From: Liz Annalls [REDACTED]
Sent: 11 January 2021 16:27
To: Planning.Responses <Planning.Responses@arun.gov.uk>
Subject: RE: Planning Consultation on: Y/155/20/DOC

Application No: Y/155/20/DOC
Site Address: Land at Bilsham Road
Description of Works: Approval of details reserved by condition imposed under ref Y/91/17/OUT relating to Condition Nos 7 - landscaping & layout, 8 - Arboricultural Method Statement & Tree Protection Plan, 10 - surface water drainage, 13 - Ecological Management & Mitigation Plan, 15 - external lighting and 21 - Travel Plan.

BILSHAM ROAD, YAPTON			
Drawing Title: PRELIMINARY ENGINEERING LAYOUT. SHEET 2 OF 2			
Client: BILSHAM ROAD DEVELOPMENT LLP			
Scale: 1:500 @A0	Date: FEB 20	Designed: NA	
Drawn: LS	Checked: JH	Approved: GG	
Job No: 19-326	Drawing No: 19-326/010	Rev: J

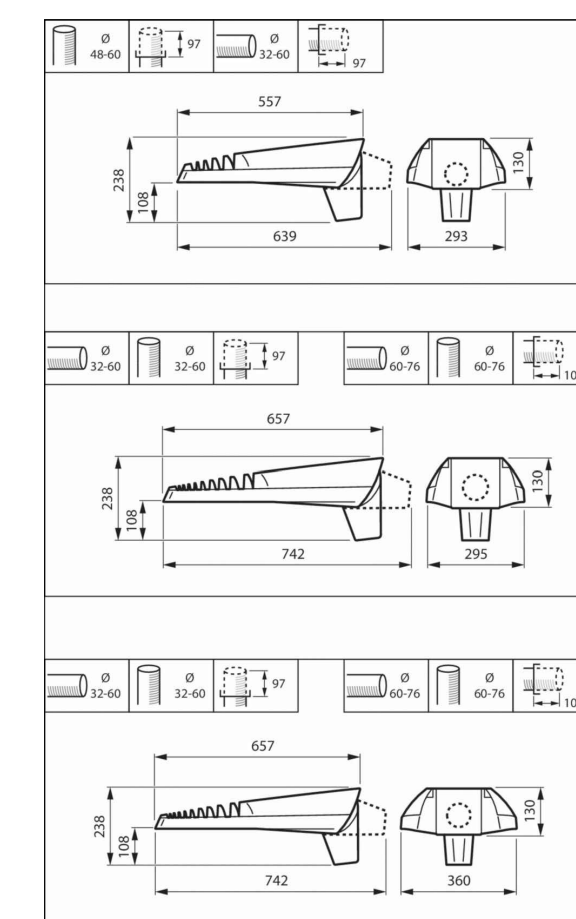
Please can further information relating to the lighting scheme onsite be submitted with this application, including the details of the chosen light fittings for both external site lighting but also the external lighting on each property along with their locations. The information provided on the preliminary engineering layout is not sufficient. The

application should be aware that the lighting will need to ensure there is no light spill towards any roofs, hedgerows and trees as this would disturb any foraging or roosting bats.
